**6 - 16 ATCHISON STREET
ST LEONARDS**

S75W ACCESS REVIEW

AMENDED DESIGN

6 June 2013

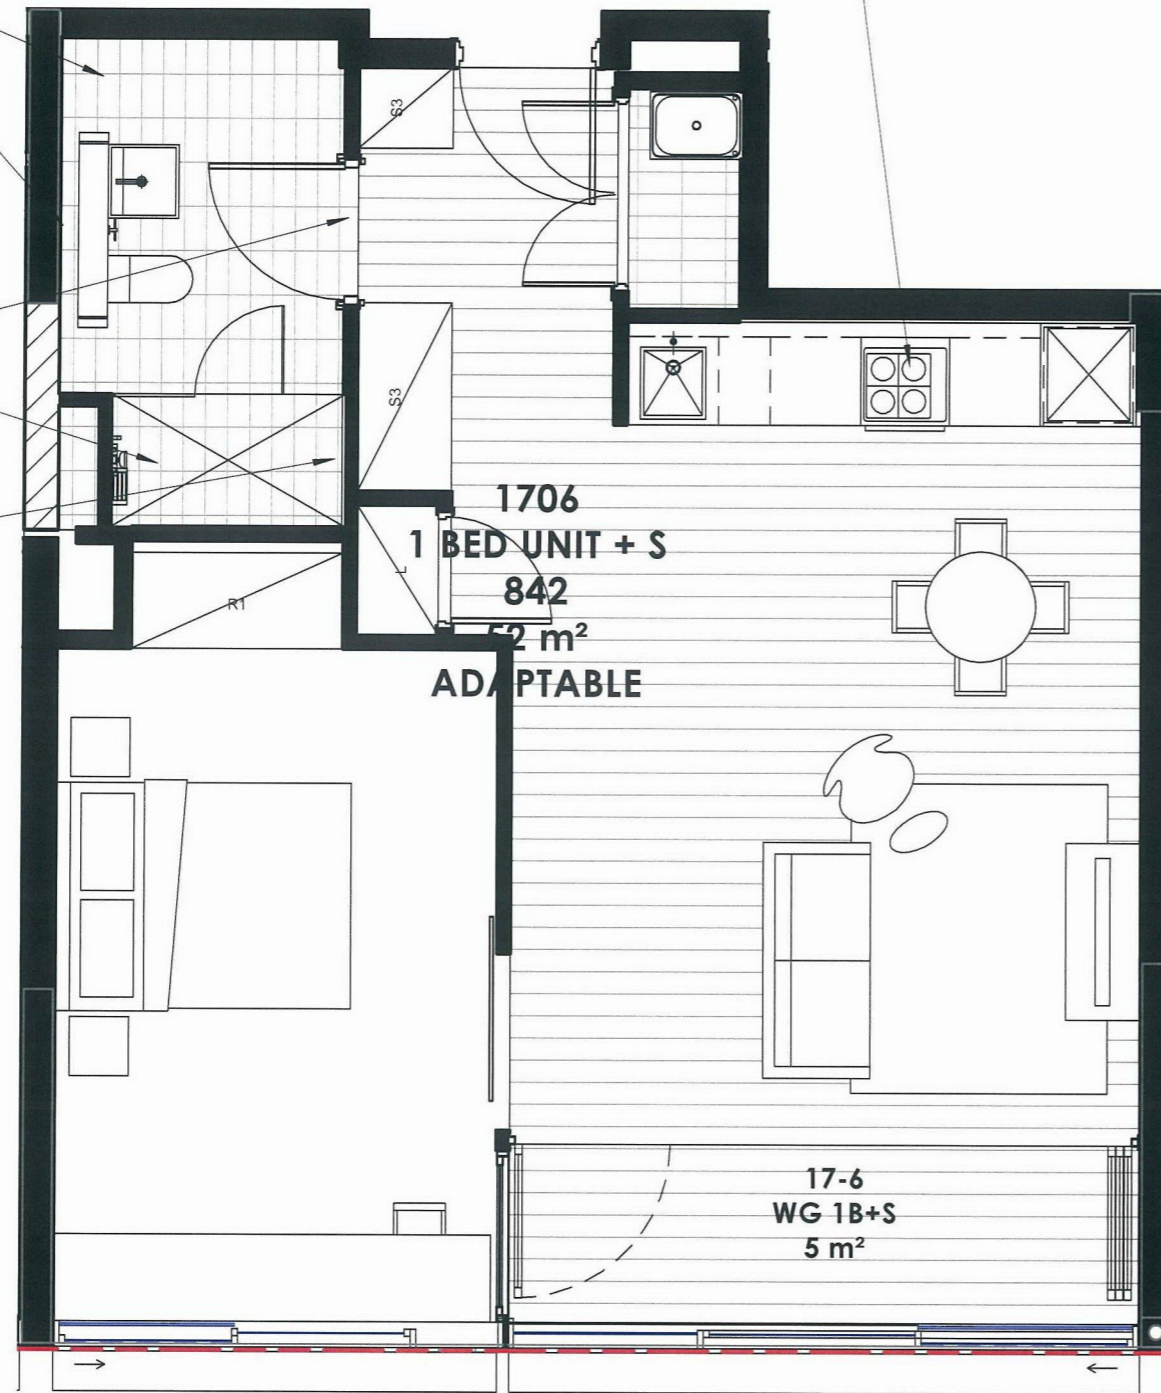
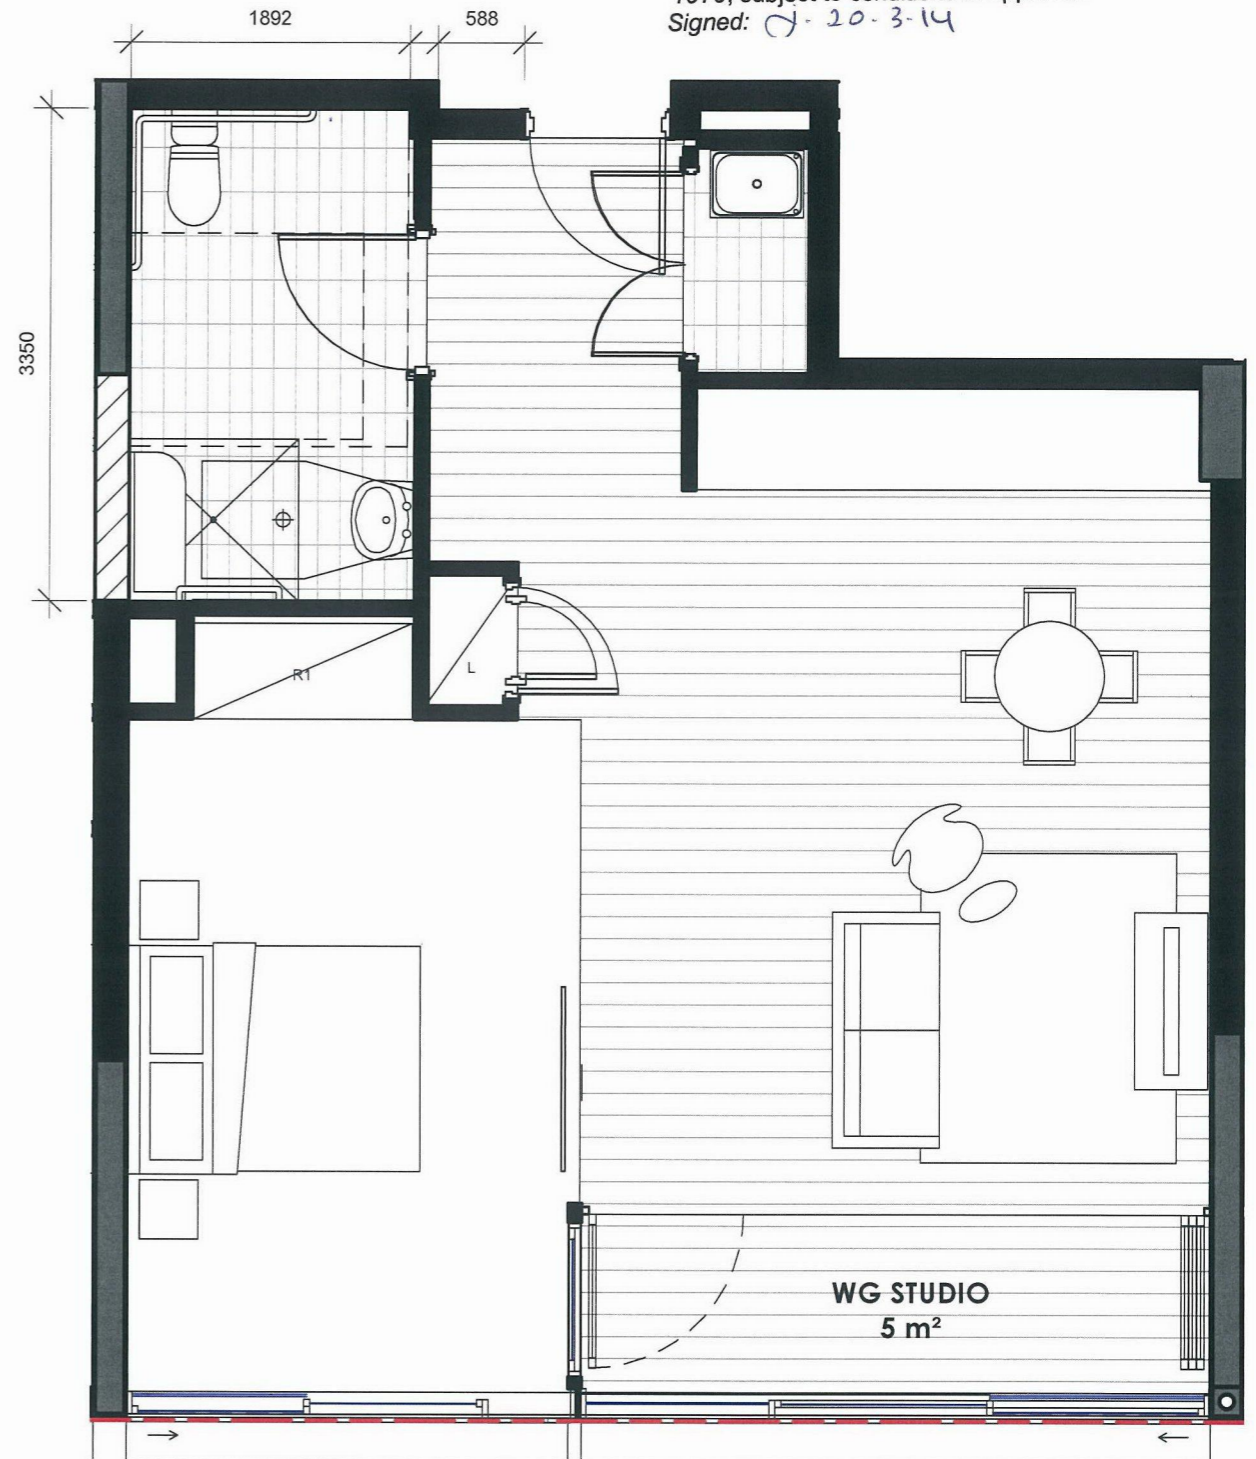
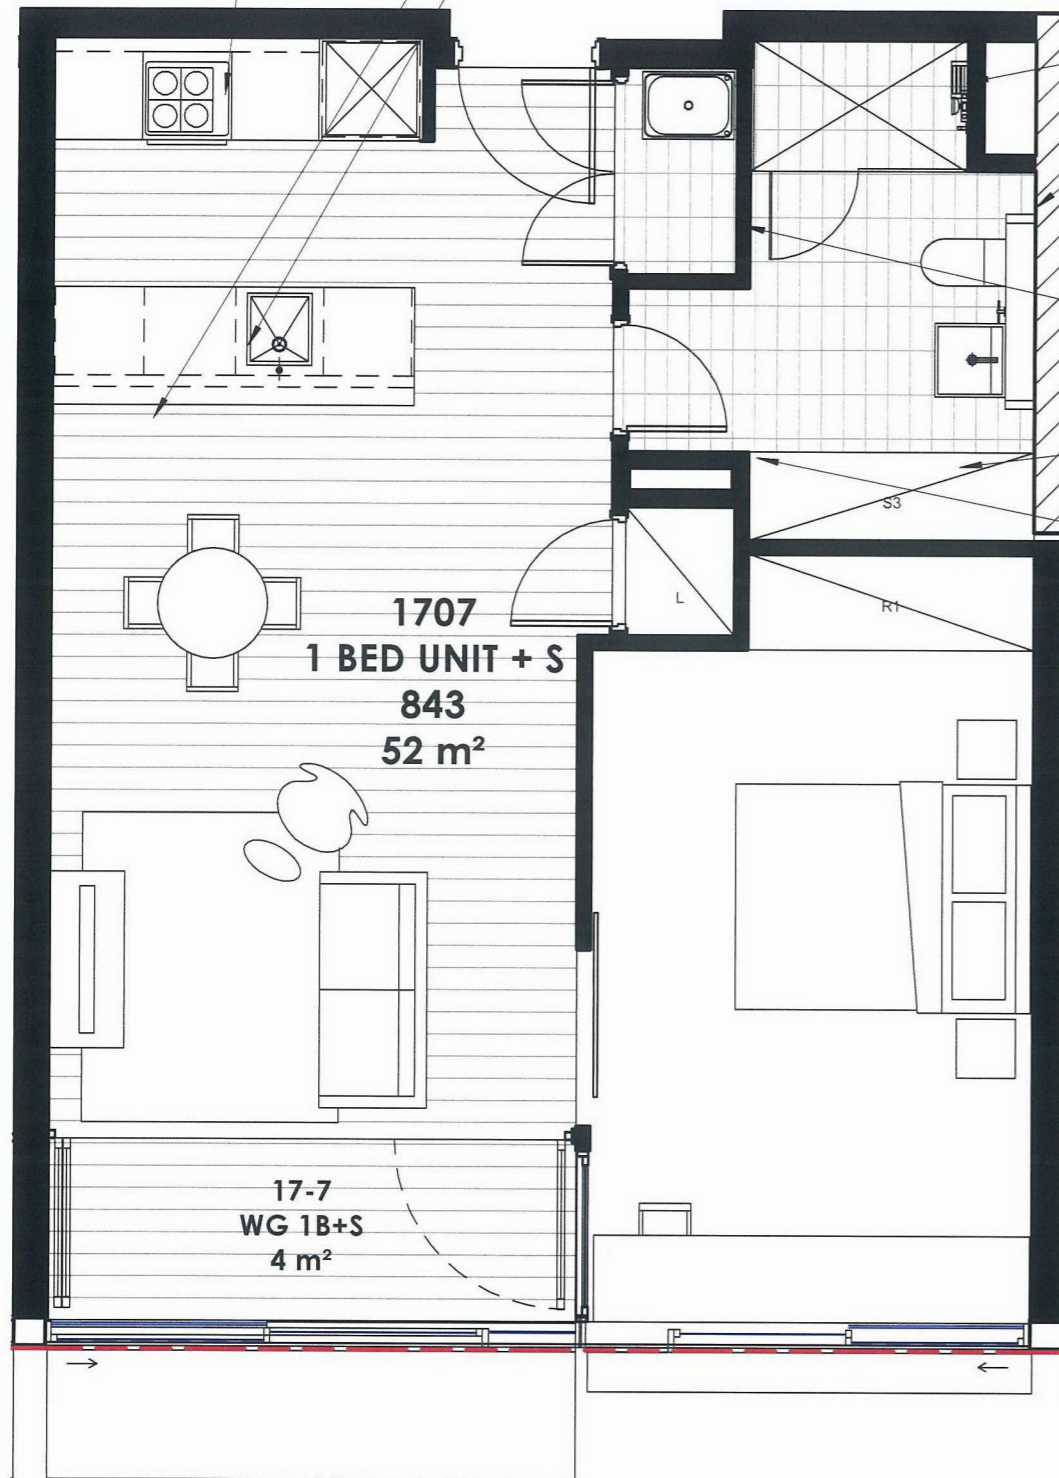
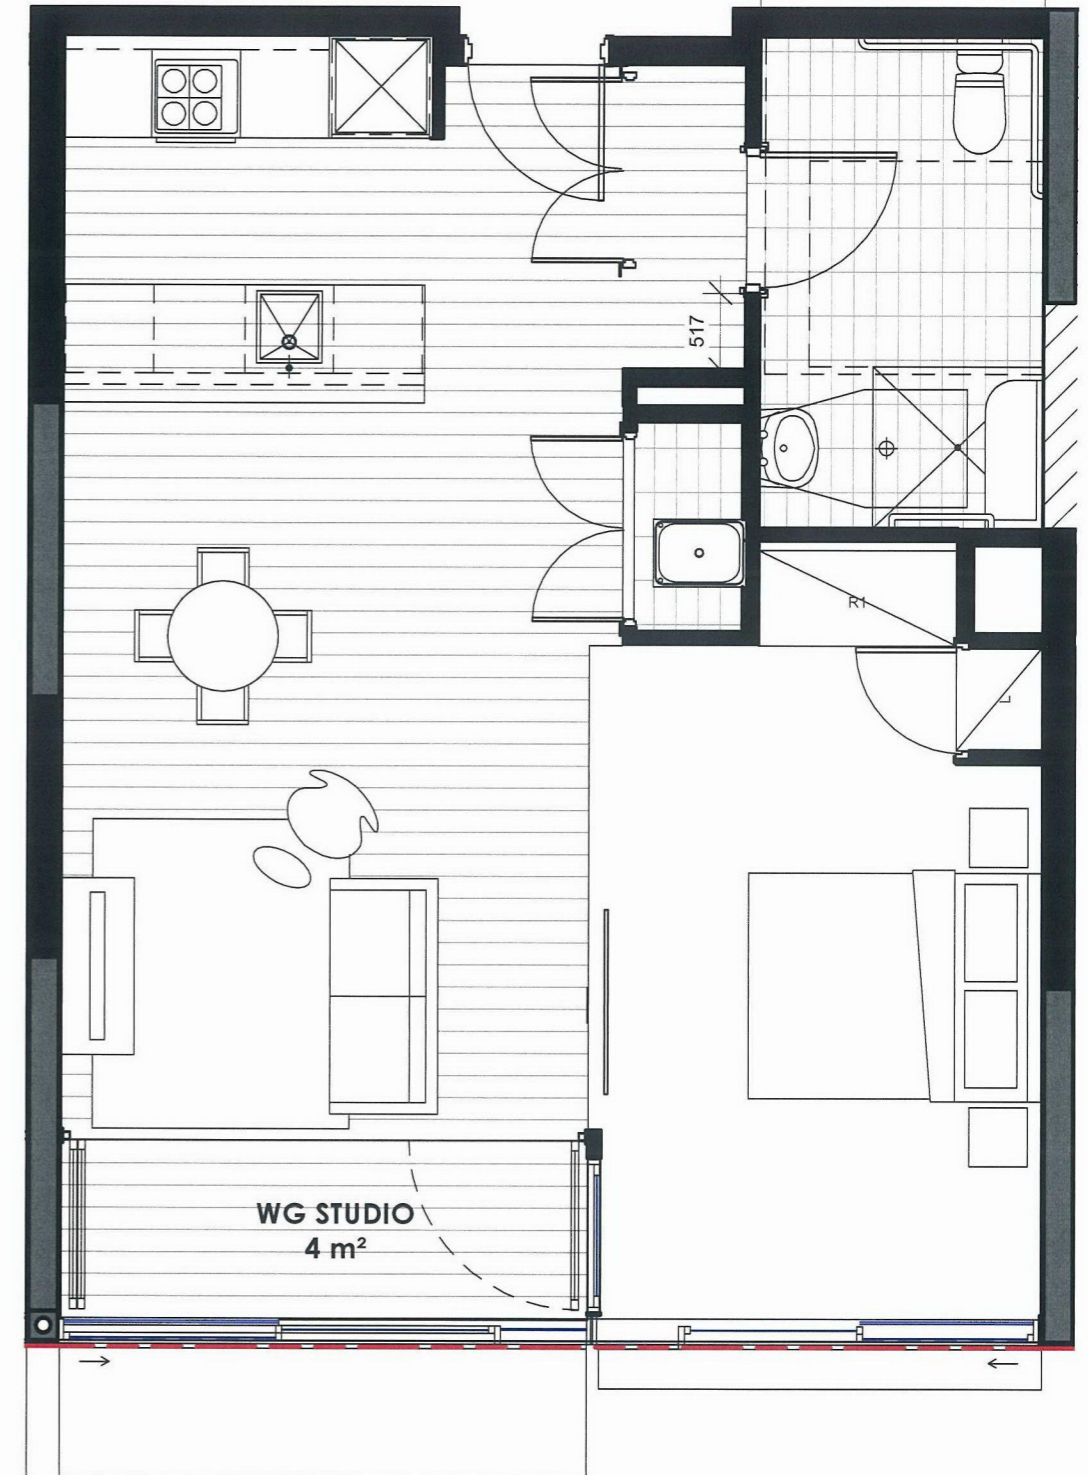
The following assessment has been made from GA drawings for Units 1.18 and 2.37 to ensure compliance with AS1428.1:2009.

There is an accessible path of travel to and through the unit entry door, shown with 850mm clear width with suitable latch side clearance on both sides, compliant with AS1428.1:2009. The internal door to accessible bathroom can achieve the required 850mm min. clear width with suitable door circulation area. There is a 1000mm min. clear width path of travel throughout the apartment that links the key areas: living, bed, laundry and kitchenette. This dimension is increased outside the bathroom doorway to satisfy AS1428.1 circulation requirements for wheelchair users.

There is at least 1000mm min. clear width is provided each side of bed, and 1540mm width x 2070mm length circulation space at foot of bed as provision for wheelchair turning space. An accessible bathroom is provided with suitable overall dimensions (at least 1935mm width x 3350mm min. length) to include a shower, toilet, wash basin and circulation spaces compliant with AS1428.1:2009. There is suitable 1550mm min. diameter circulation area in front of kitchen and laundry area to allow for wheelchair manoeuvrability.

- (i) Provide slip-resistant floor surface with min. wet pendulum test rating of 'X' (under HB197/AS4856) in adaptable unit bathroom, kitchen and laundry. Test results will be required at OC Stage.
